Address: 313, Cliffe Lane, Cleckheaton, bd194sb

Application number: 2026/91912	
What is the application for?:	Removal/variation of conditions 2 and 3 (plans) on previous permission 2023/9296
Address of the site or building:	rear of, 271, Cliffe Lane, Gomersal, Cleckheaton, BD19 4SB
Postcode:	LS11 8PG

User comments

Planning Site Layout

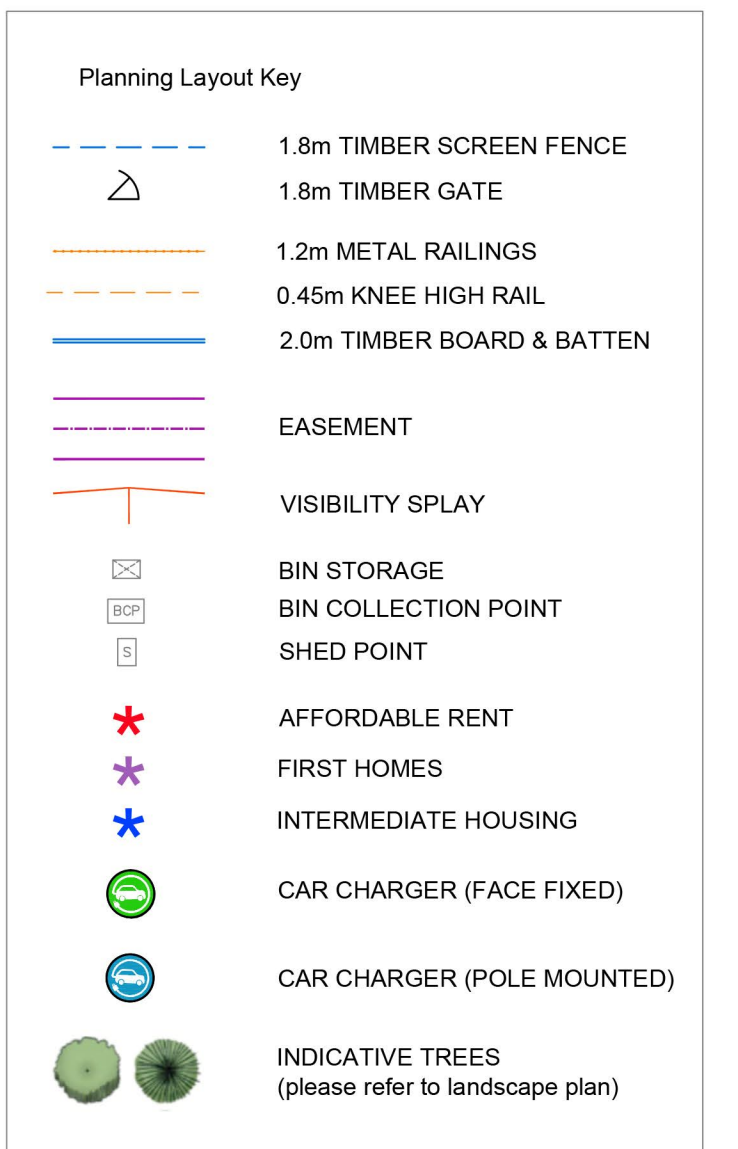
Type of comment: An objection	
Do you wish your comments to be published on the website anonymously?	No
I live on Cliffe Lane, and my property and rear garden directly adjoin the application site, and I object to this application, noting that I also objected to the original application (2023/92966). Given that the council has already approved planning permission for 97 dwellings under application 2023/92966, my objection is directed specifically at the acceptability of the replacement plans, house types and plot arrangements now proposed. The original officer assessment explained that careful consideration had been given to the shape, massing and design of the approved dwellings. It stated that the approved scheme used a varied range of house types, including tailored designs responding to the multiple constraints and challenges of the site. That detailed design response formed part of the basis upon which officers concluded that the development was of a high standard and acceptable. The current application now seeks to replace those approved designs with a substantially replotted scheme using a different range of standard Keepmoat house types. Building footprints, dwelling designs, windows, gardens, parking areas and boundaries have changed across the development. Despite those changes, the application does not provide sufficient detailed information to demonstrate that the revised scheme will protect the privacy and living conditions of neighbouring residents. This is particularly important along the southern and eastern boundaries, including the relationship with Cliffe Lane, because the site has changes in level and the effects of a new dwelling cannot dependably be judged from a two-dimensional site plan alone. The applicant has not given clear, plot-specific information showing: * existing and proposed ground levels:

- existing and proposed ground levels;
- * finished floor and ridge levels;
- * scaled cross-sections between the proposed dwellings and Cliffe Lane;
- * the location and height of habitable-room windows;
- * the actual separation between those windows and existing houses and gardens;
- * whether overlooking would be direct, oblique or increased by differences in level;
- * the effect of the revised dwellings on the privacy and usability of existing rear gardens.

The general statement that council separation distances have been followed is not an adequate substitute for this information. Numerical separation distances cannot, by themselves, demonstrate that a proposal is acceptable where land levels, orientation, window positions and the sensitivity of existing private gardens have not been properly assessed.

The council should also not assume that the acceptability of the original scheme automatically establishes the acceptability of the revised scheme. The original permission approved specific dwelling designs in specific locations, with assessed heights, building dimensions, roof forms, window positions and separation distances. Those details were fundamental to the council's conclusions on design, overlooking, privacy and overbearing impact. The current application proposes to replace many of those details and must therefore demonstrate afresh that the revised scheme protects neighbouring residents.

Accordingly, the application has not demonstrated that the revised development would avoid unacceptable overlooking, loss of privacy and overbearing effects on neighbouring properties. It has therefore not provided a sound basis upon which the council can conclude that the living conditions of existing residents would be protected.
